**KIRKLEES METROPOLITAN COUNCIL  
INVESTMENT & REGENERATION SERVICE**

**DELEGATED DECISION TO DETERMINE PLANNING APPLICATIONS**

Reference No:	<b>2024/62/90819/E</b>
Site Address:	3, Lower Putting Mill, Denby Dale, Huddersfield, HD8 8SX
Description:	Erection of single storey front extensions with first floor balcony
Recommending Officer:	Jennifer Booth

**DECISION – CONDITIONAL FULL PERMISSION**

Title -
3D PERSPECTIVES

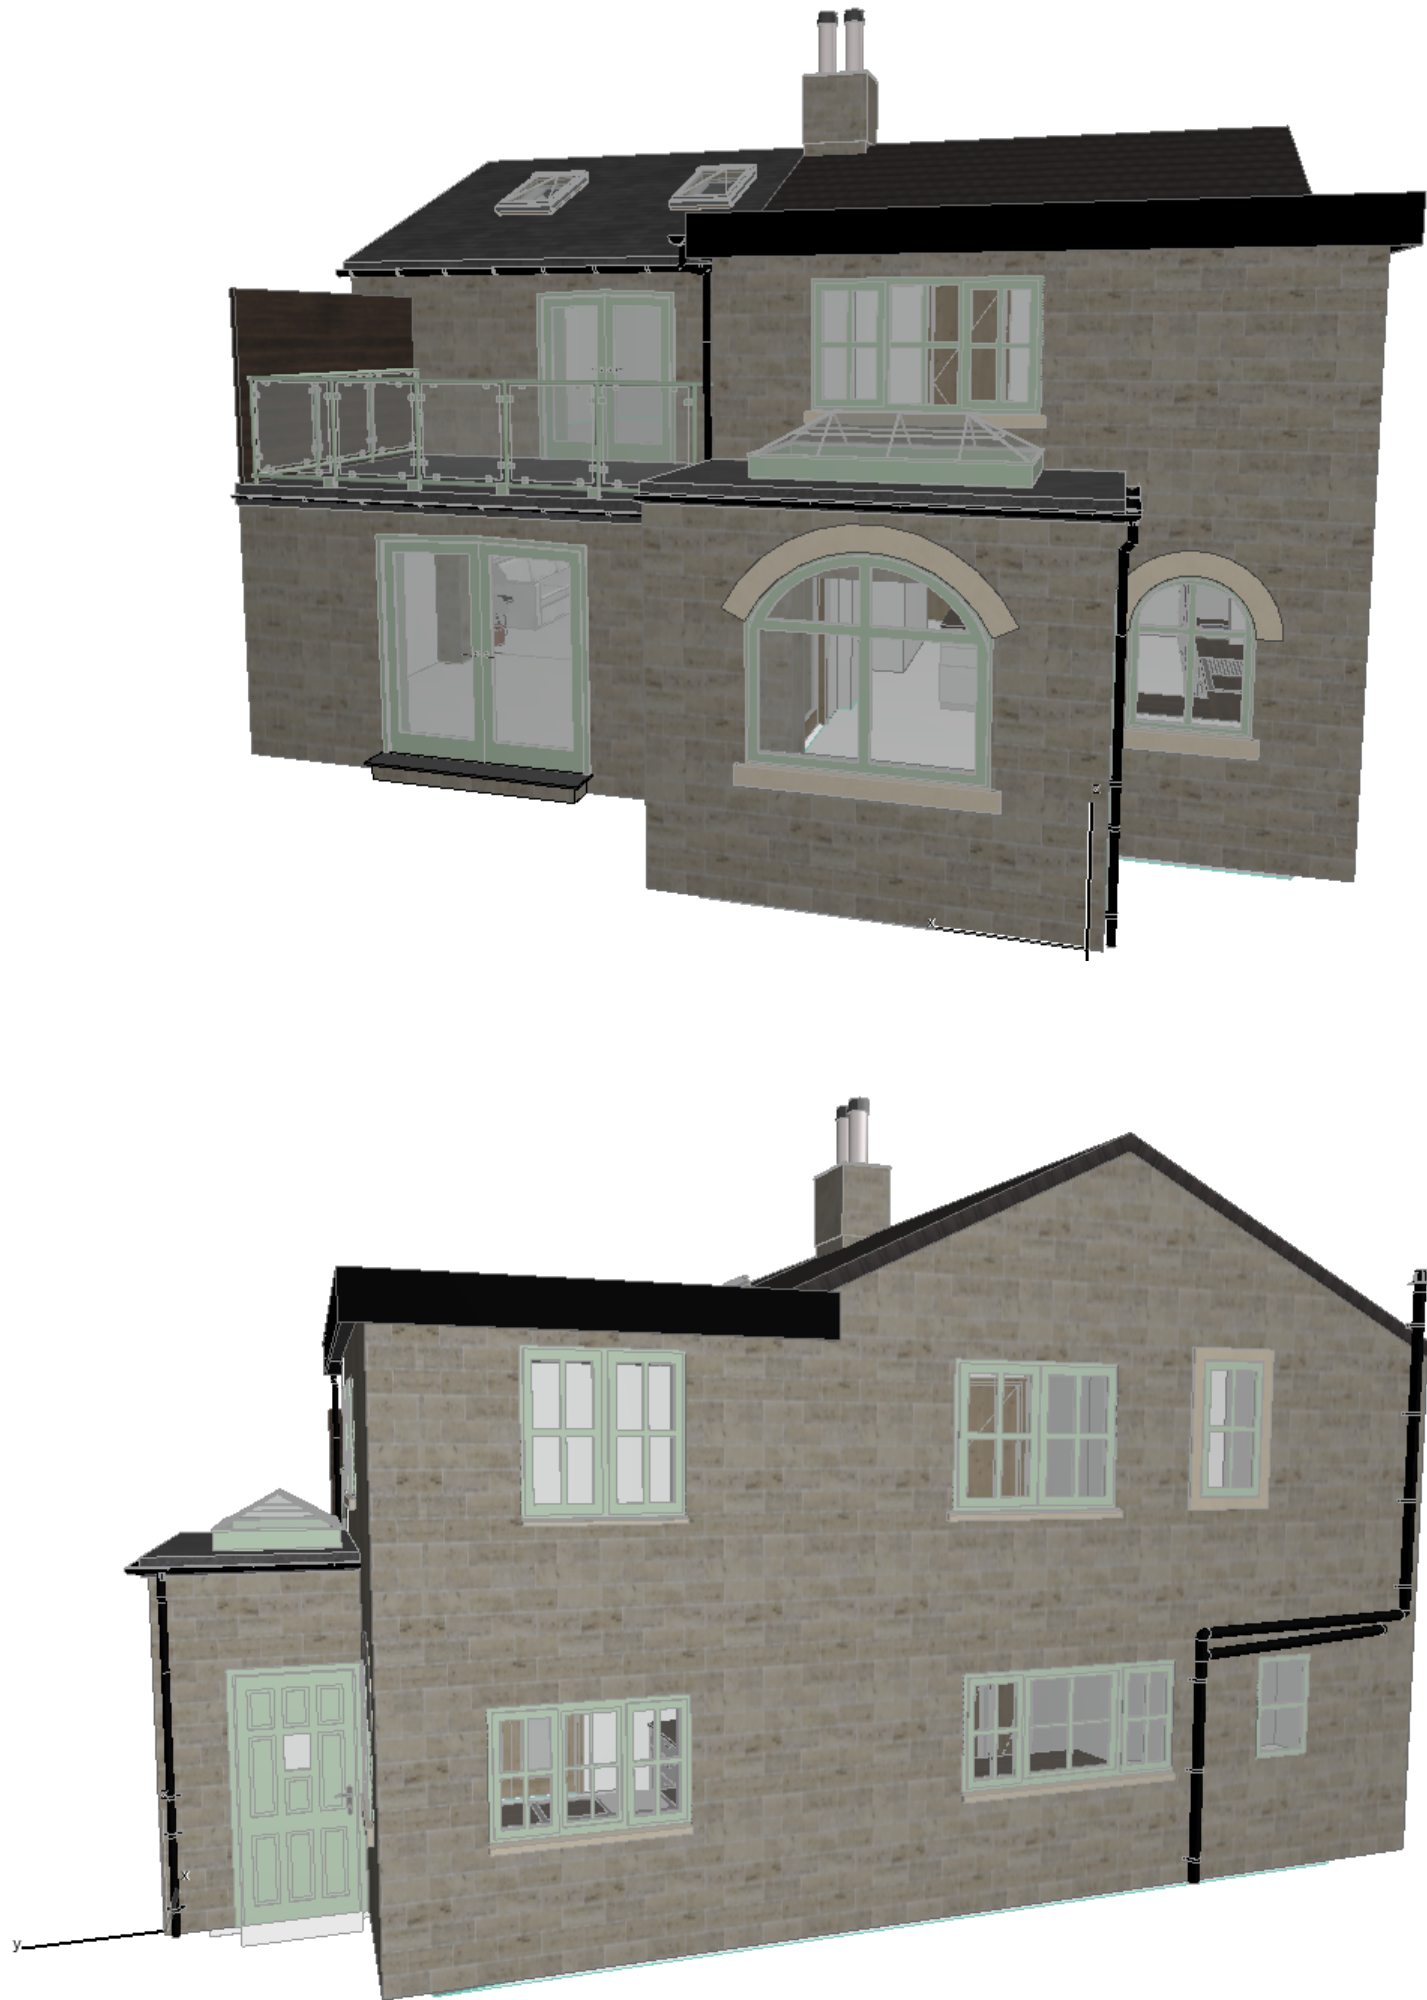
Although the infill extension on the front is larger than the average porch, it is infilling the area to the side of an existing extension whilst retaining a modest amenity space to the front. The scale can be considered to be appropriate. The use of stone for the walling would match the main house. The balcony over would be concealed to a degree by the existing extension. As also noted previously, the group of properties within which the host property is positioned are not a traditional street scene and as such, there is limited prominence. The infill extension and balcony can therefore be considered to be acceptable in terms of visual amenity.

Title -
PROPOSED FIRST
FLOOR PLAN

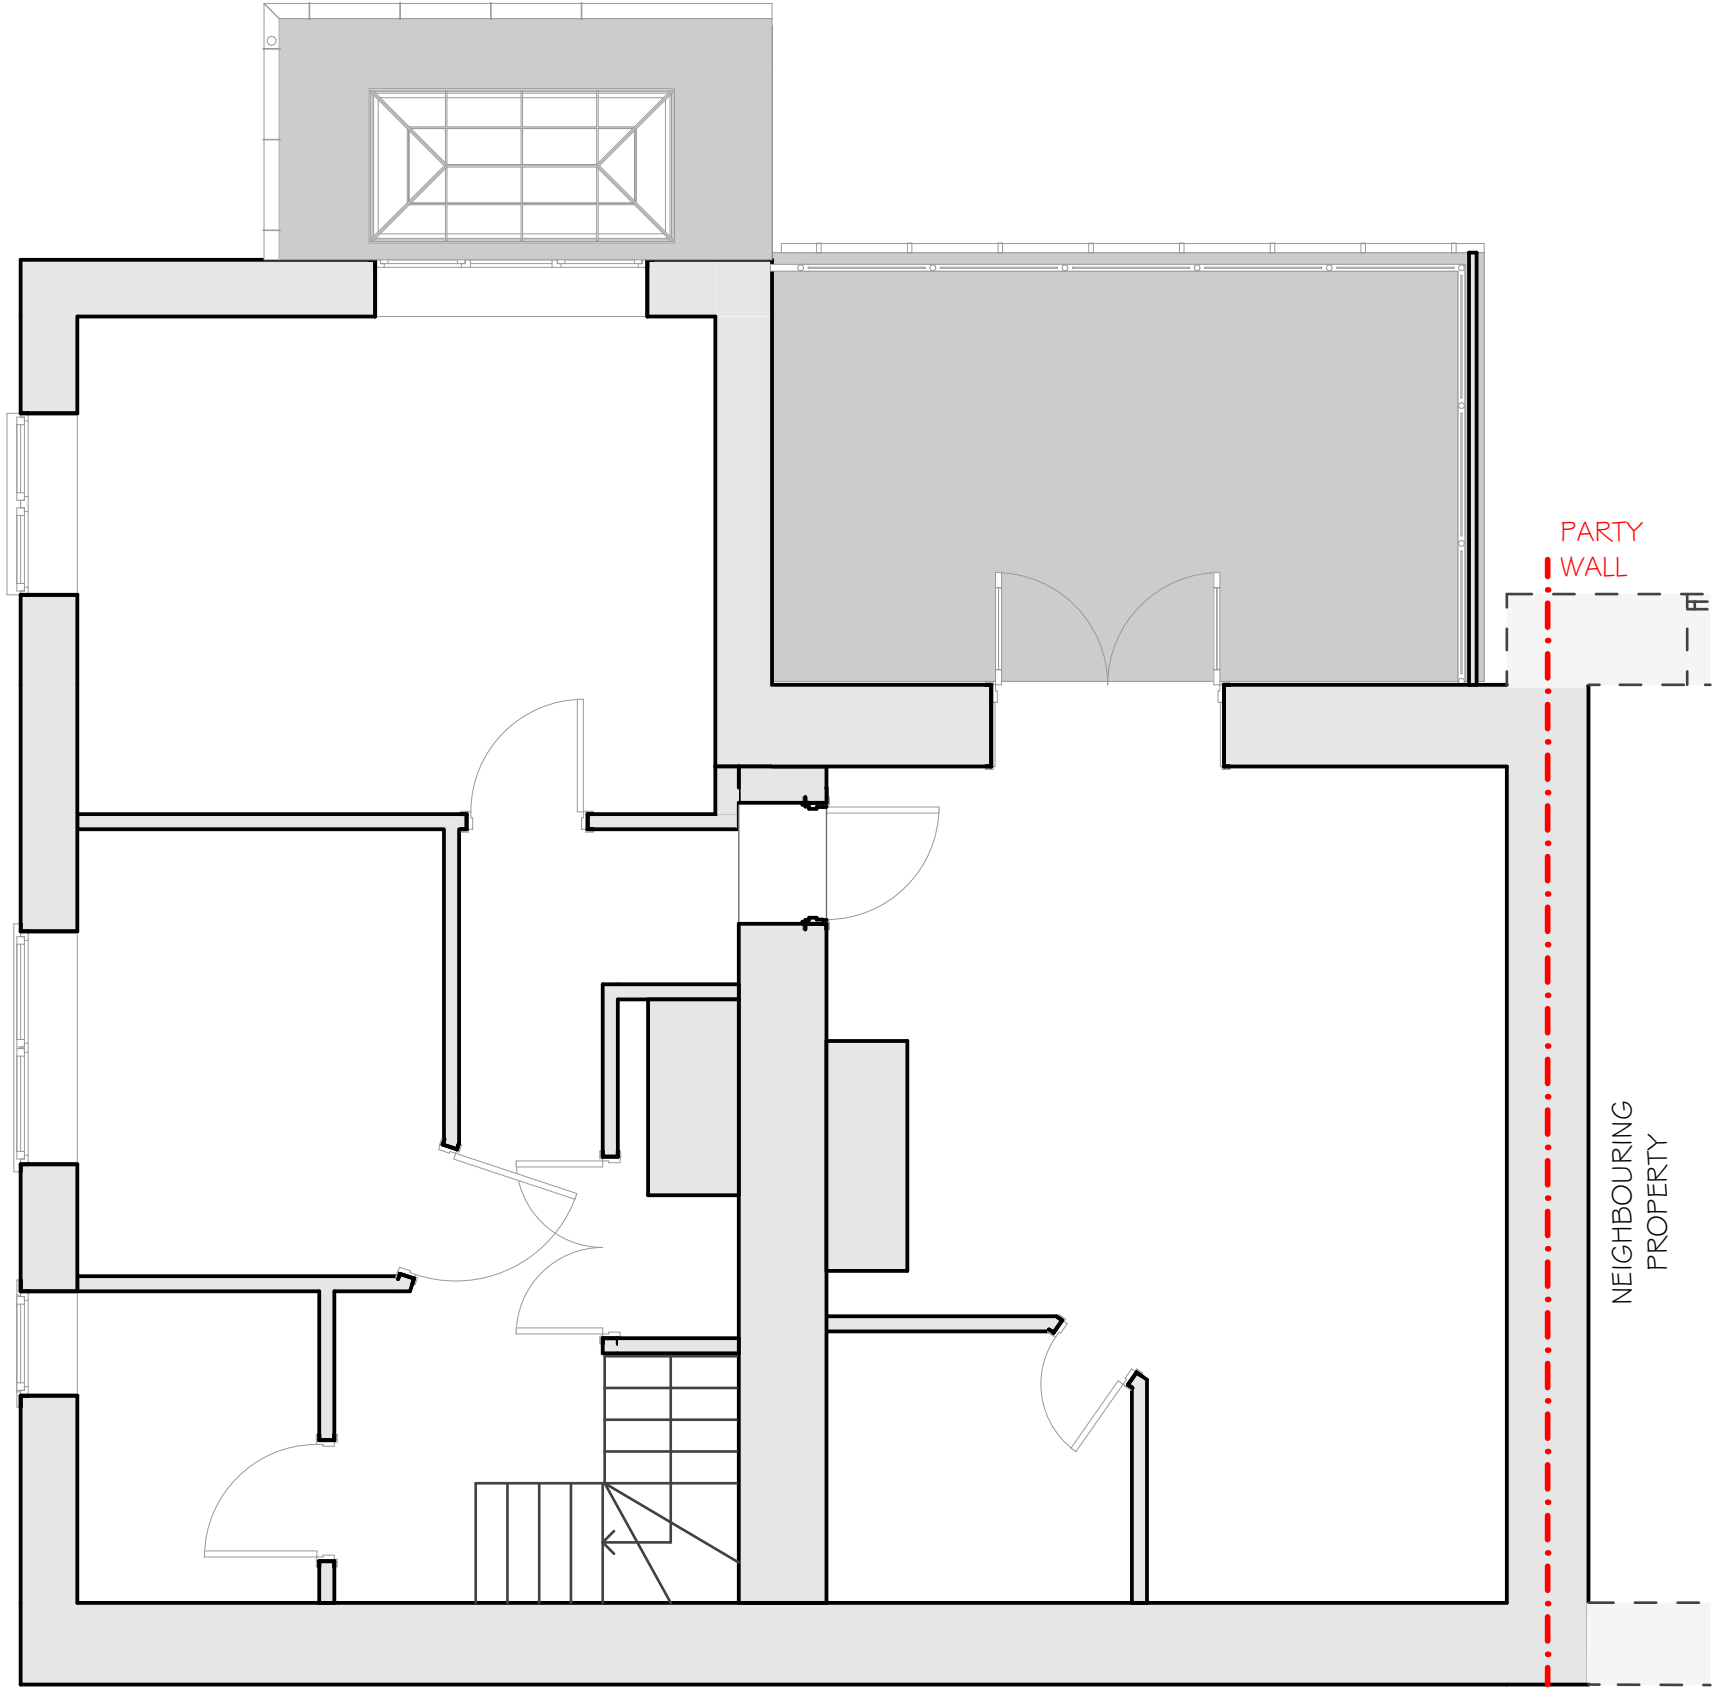
The infill extension would have a projection of 2.8m and a width of 4.6m with a balcony formed over.

The walls of the extensions would be constructed using stone and the balcony would be enclosed with a glazed balustrade on the front and a screen to the side with the adjoining property.

The infill extension would be constructed along the shared boundary. However, it is noted that the adjoining property does sit slightly proud and a little higher relative to the host property with the neighbours front door close to the boundary. As such, the 2.8m projection proposed would have limited impact.

The screen proposed for the balcony would have a greater height than a single storey extension would normally have. The nearest window for the neighbouring property is a bathroom which is not considered to be habitable. Due to the existing relationship with the neighbouring dwelling and amenity space it is not considered that the balcony will result in any loss of privacy. As such, the infill extension with balcony would not result in any significant overshadowing, overbearing or overlooking.
